Planning Officer: Simon Davis

Planning Application Ref: AW/71/18/HH

Location: 36 Kingsway, Aldwick

Description of works: Demolition of existing ground floor extensions to front of property, construction of a single storey rear extension and reworking of existing external hard and soft landscaping. This application affects the character and appearance of the Craigweil House Conservation Area.

Proposed Ground Floor Plan

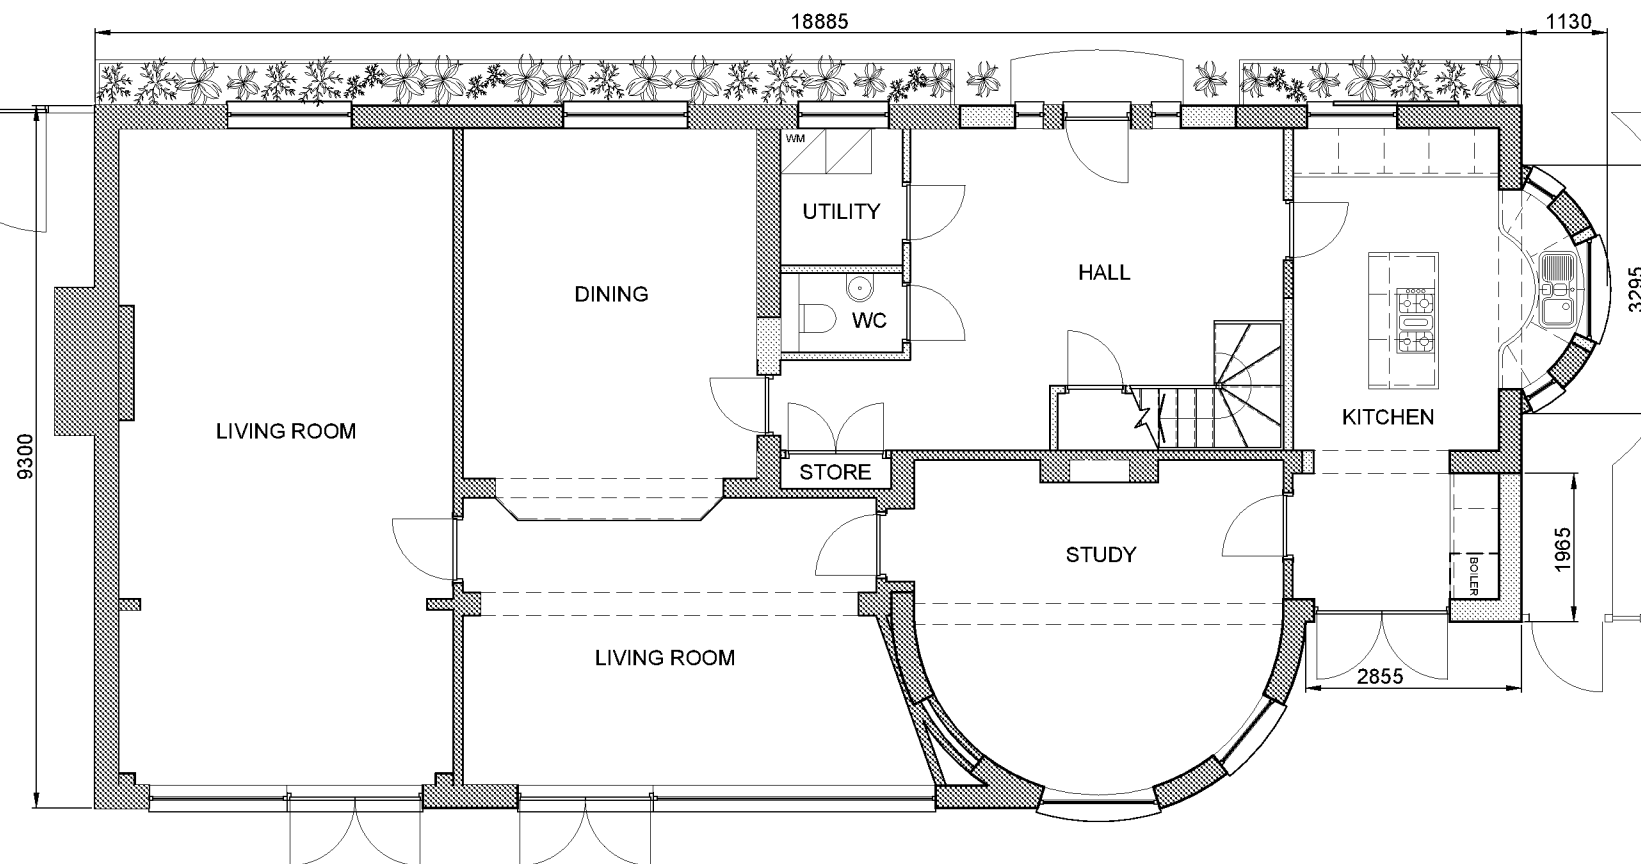
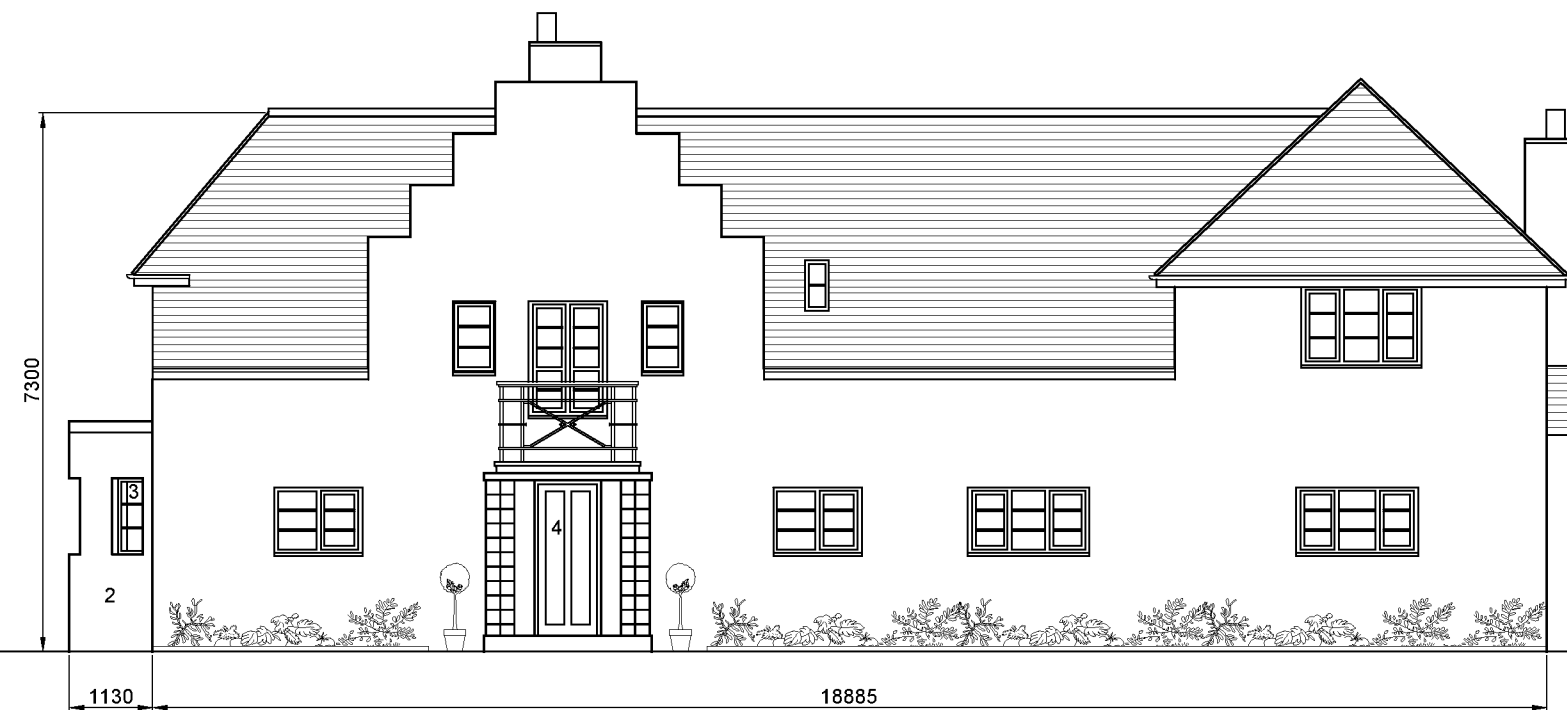
This feature is referred to in the Design and Access Statement and best illustrated in plan drawing C0019-P215G. It is not referred to in any version of the main Arboricultural Impact Assessment document. Presumably omitted initially, as excavation was not deemed to reside within the RPA of T5.

Following revision of the RPA, as agreed between all parties – excavation to facilitate construction of the eastern pillar will occur within the new RPA. As such, there will need to be some reference to methodology and inclusion of soil/root protection measure to limit the effects on tree health.

If the application as it stands is granted consent, then the general principles stated within the AIA relating to tree root pruning can be deemed adequate. There remains a high risk of harmful soil contamination if as expected concrete is used to form an adequate footing for the pillar. I recommend we seek the following addition to their AMS:

- ***The excavation for and construction of; footings for the eastern pillar (driveway access) within the RPA of T5, will be undertaken with care so as to avoid unnecessary damage to tree roots. Only hand-digging is permitted, and of sufficient depth and width so far as is necessary. Leachate from curing concrete can be toxic to tree roots therefore all pits are to be lined with impervious membrane before pouring concrete.***

| Dwg No.    | 601           |                          |

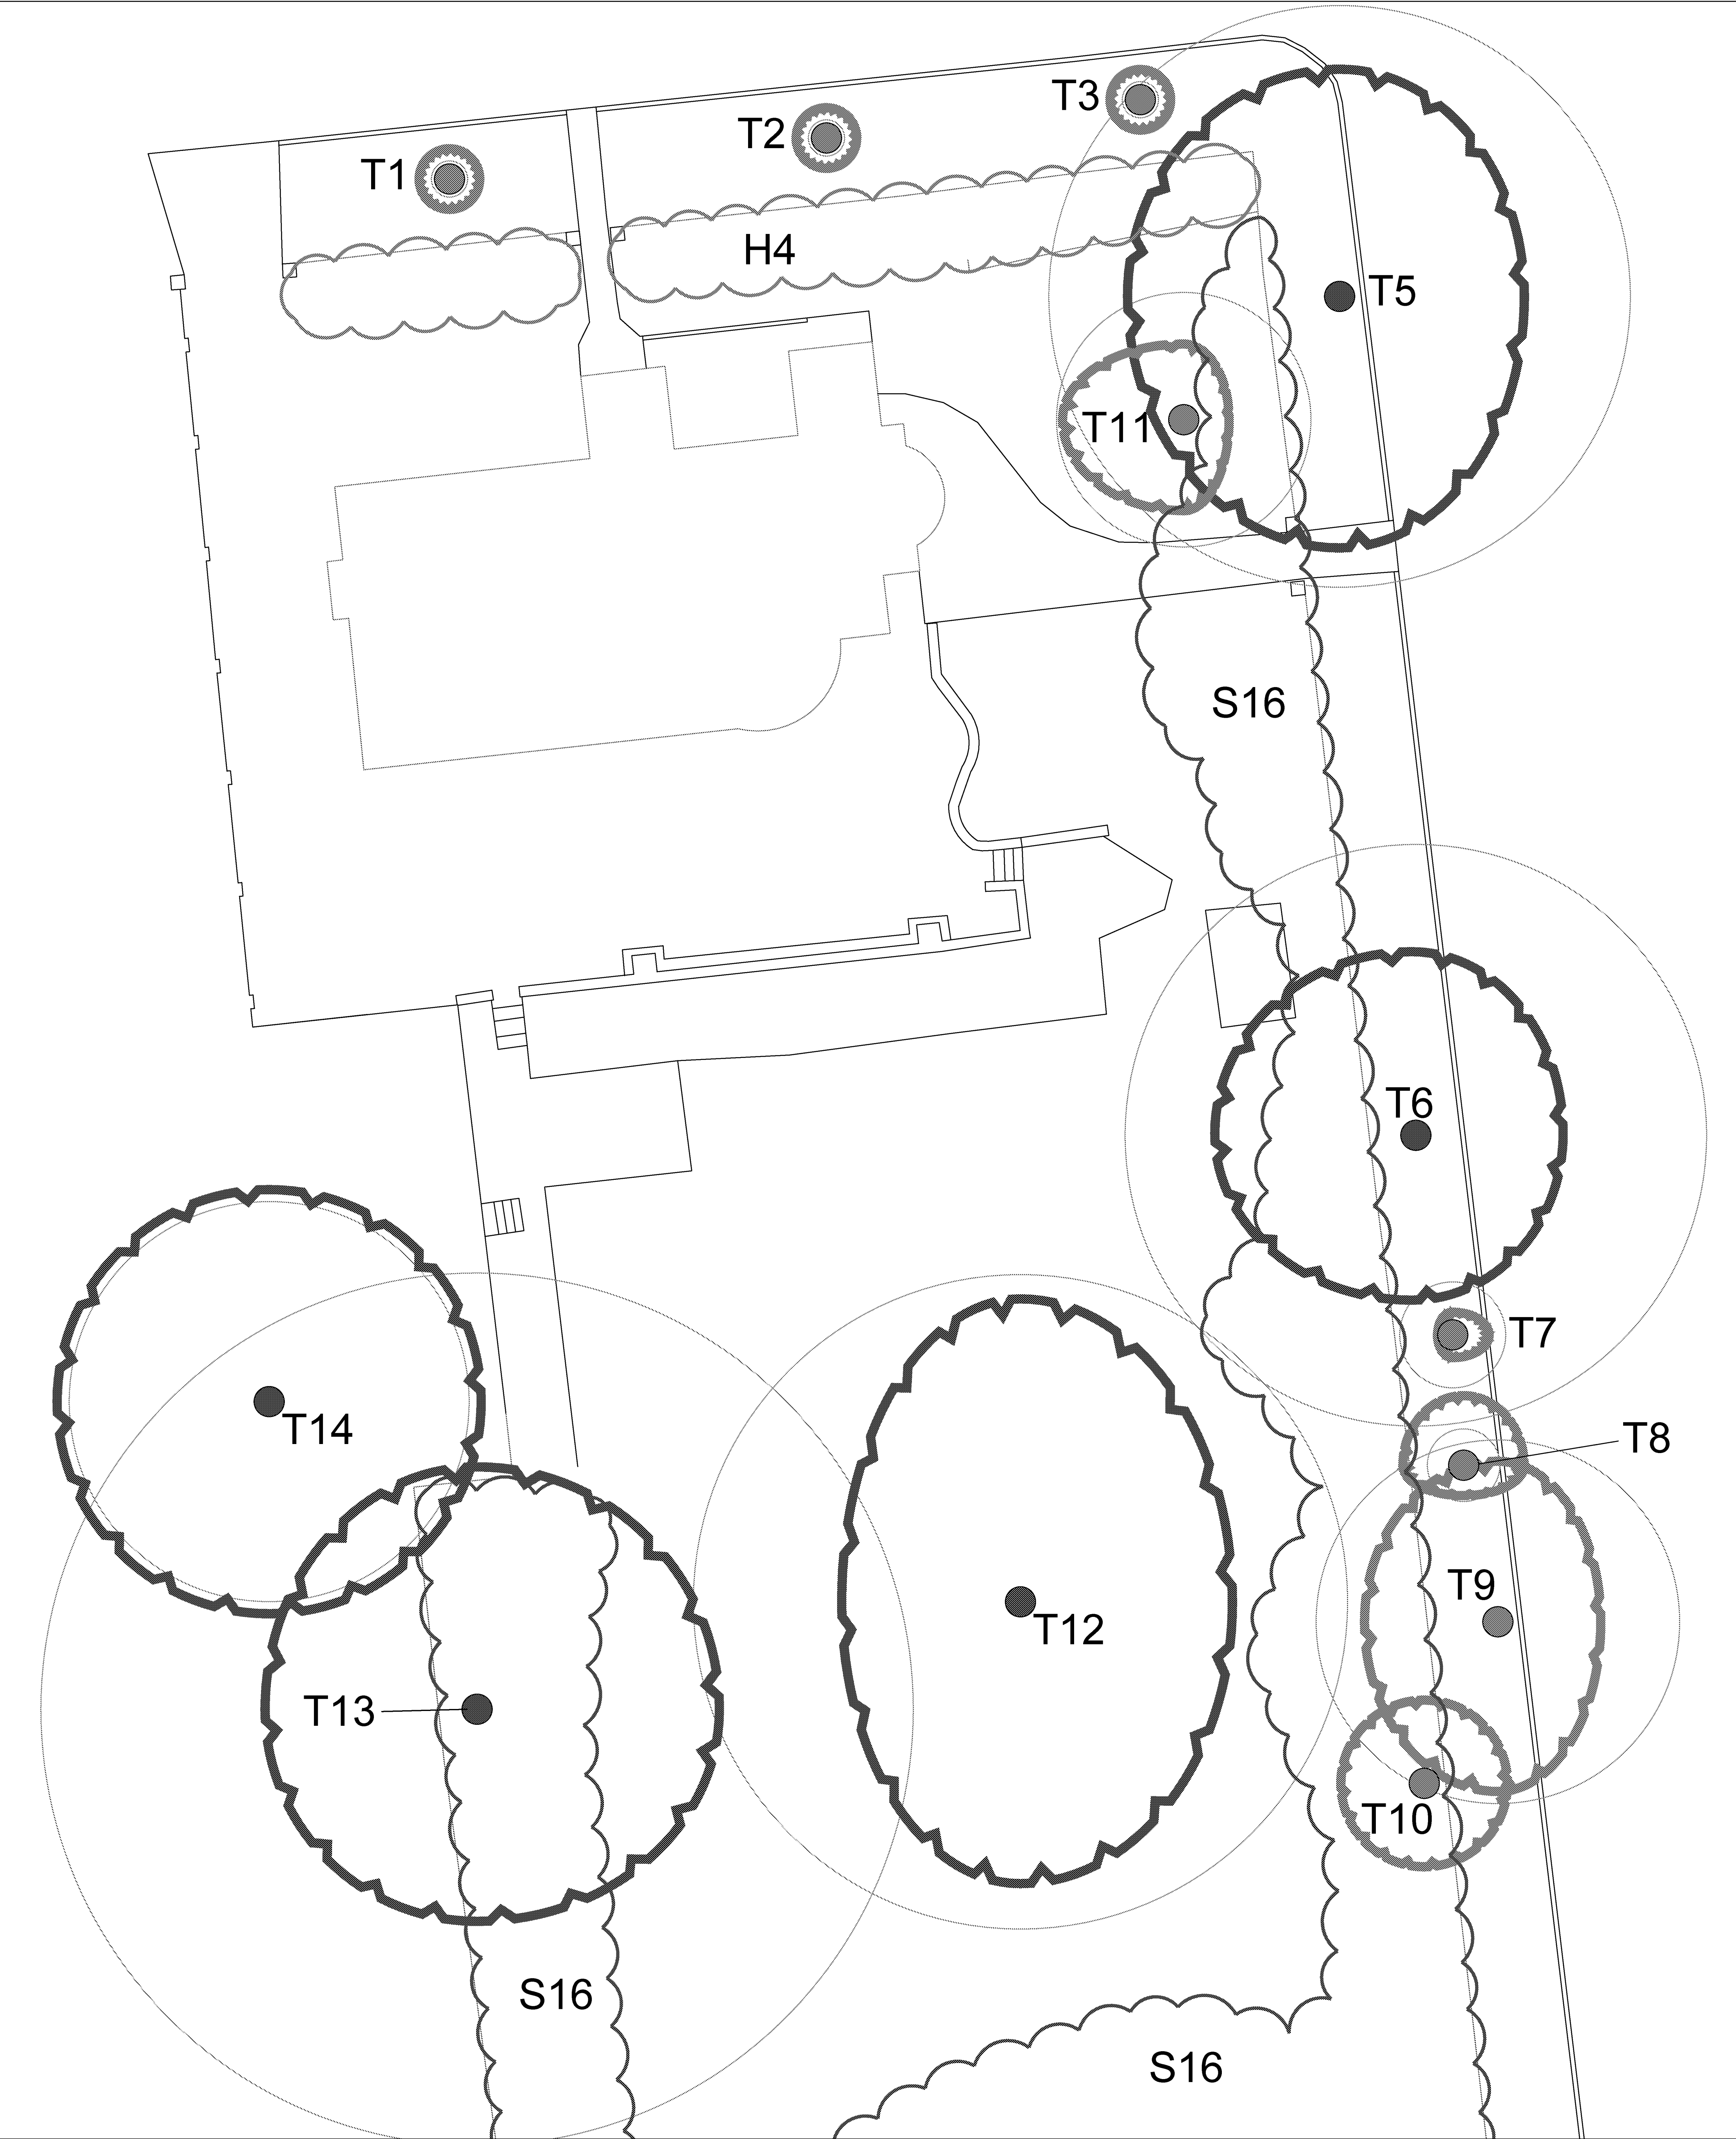
- The Tree Survey data mostly accords with the requirements of BS5837:2012 and I agree with the retention category ratings but there is a significant omission; namely the absence of Root Protection Area (RPA) measurements from the tree survey schedule or elsewhere in the AIA . This element of tree survey data is fundamental to achieve adequate tree protection.

- Of specific interest is T5 (horse chestnut), the subject of an Order (TPO/AW/5/16) and listed as T-1 on the associated Schedule. I measured its stem diameter at 1.5m height to be 895mm and not the recorded 800mm. This may seem a small matter but recognising the ideal RPA is significant in the context of this development proposal - which I return to later in more detail.

- As it stands, I must raise an **OBJECTION** to this application in its current form.
- RPA measurements (radial spread and area) must be added to the tree survey schedule to inform the process. The greater measurement of 895mm has now been recognised and informs the revised RPA (polygon). The agreed RPA broadly follows the indicative plan below but rejects the irregular element over carriageway in Kingsway and compensates with a comparable area of extension to the south – which I am able to support. The mutually agreeable RPA is detailed on the **AIA/AMS drawing no.602 – Rev B**.

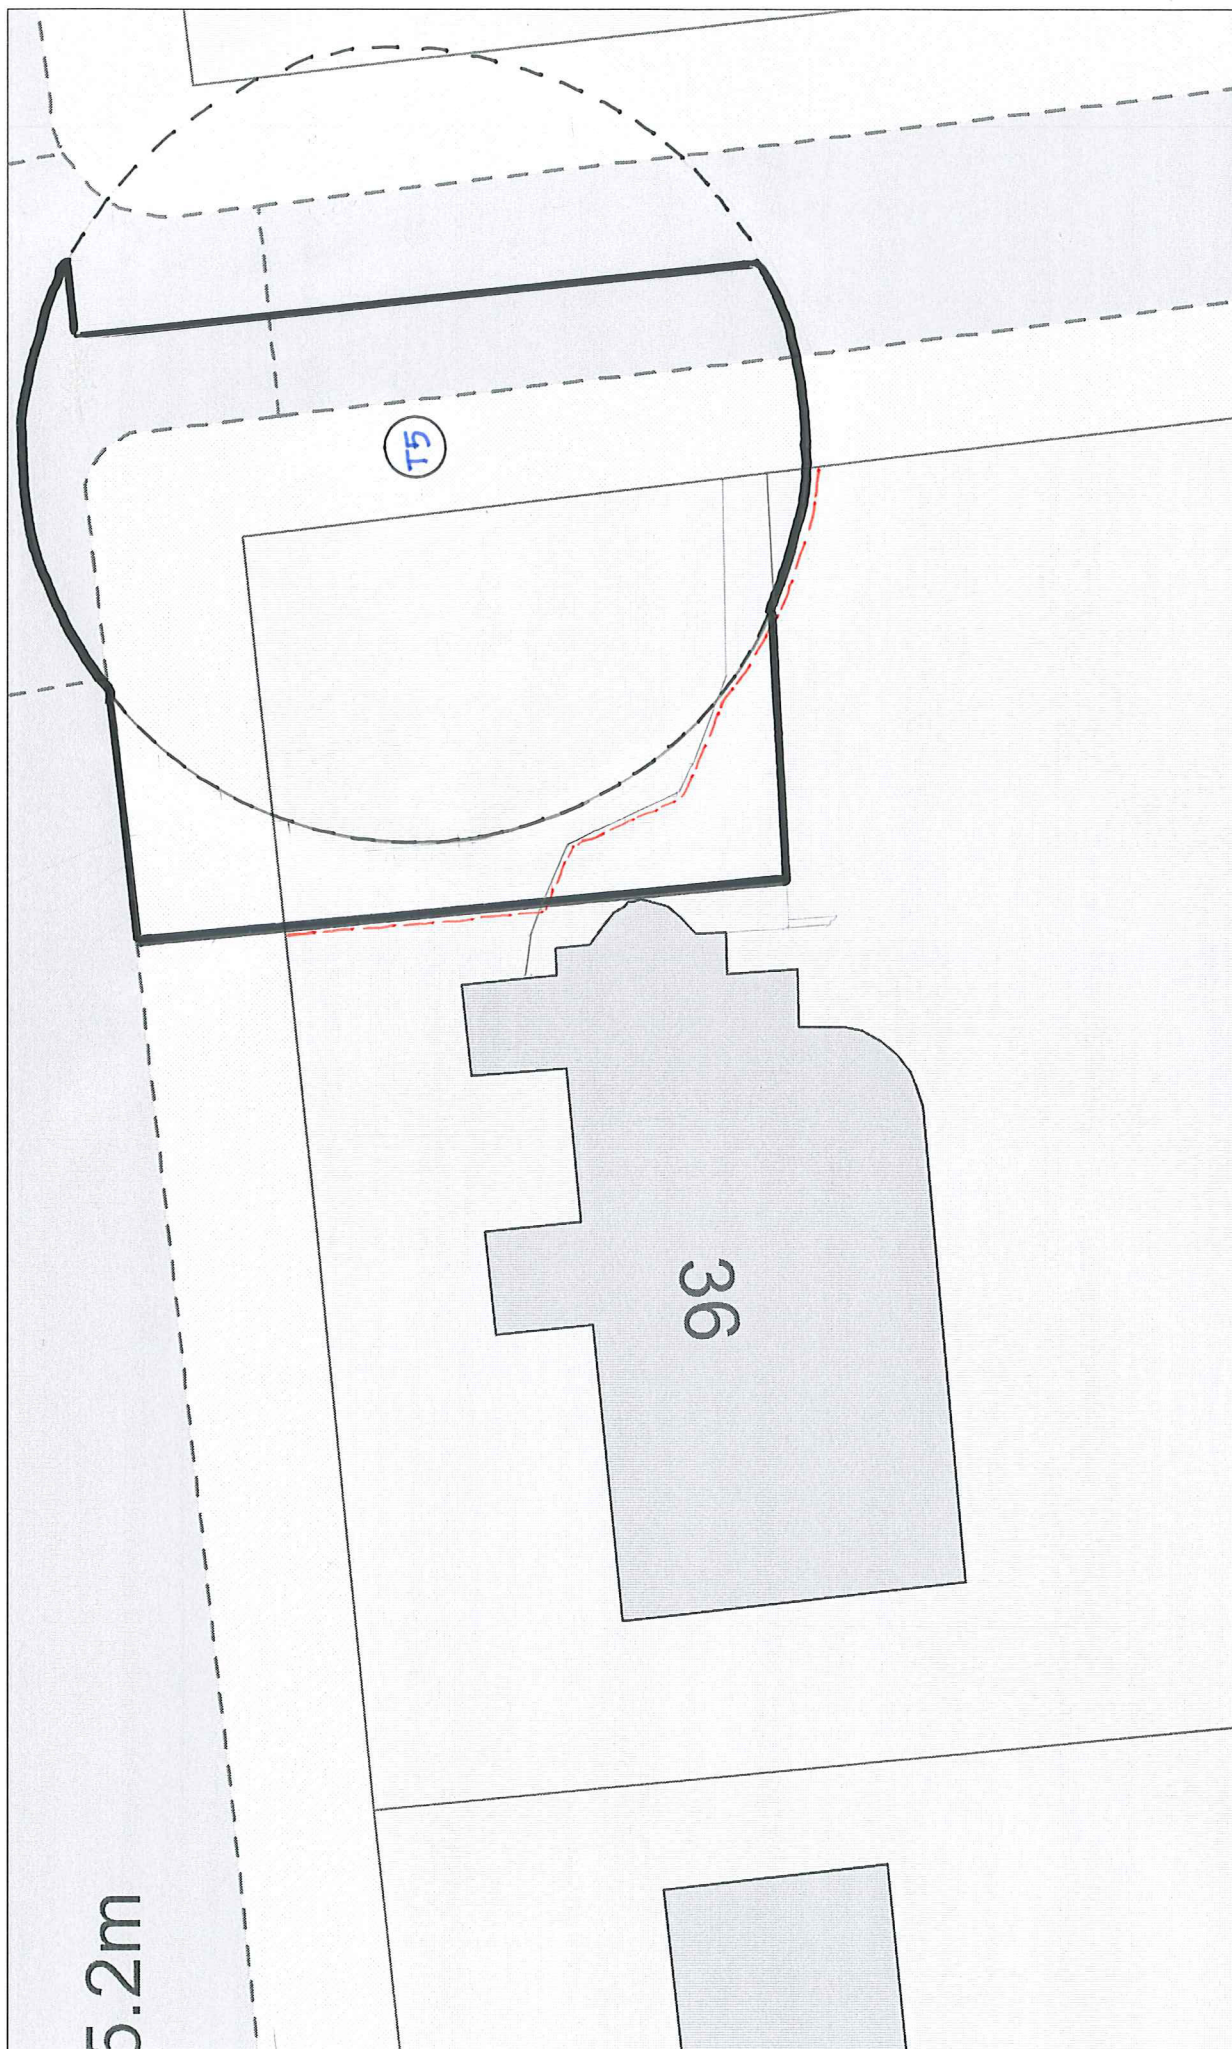
- I attach an indicative plan showing the desired RPA outcome for T5 to be adopted in a revised plan drawing, which can better inform a design. If necessary, I would be happy to meet the applicant’s agent to discuss the methodology and measurements that support this plan. Site meeting with Arboricultural Consultant, Architect and Residents held on 3rd July 2018.
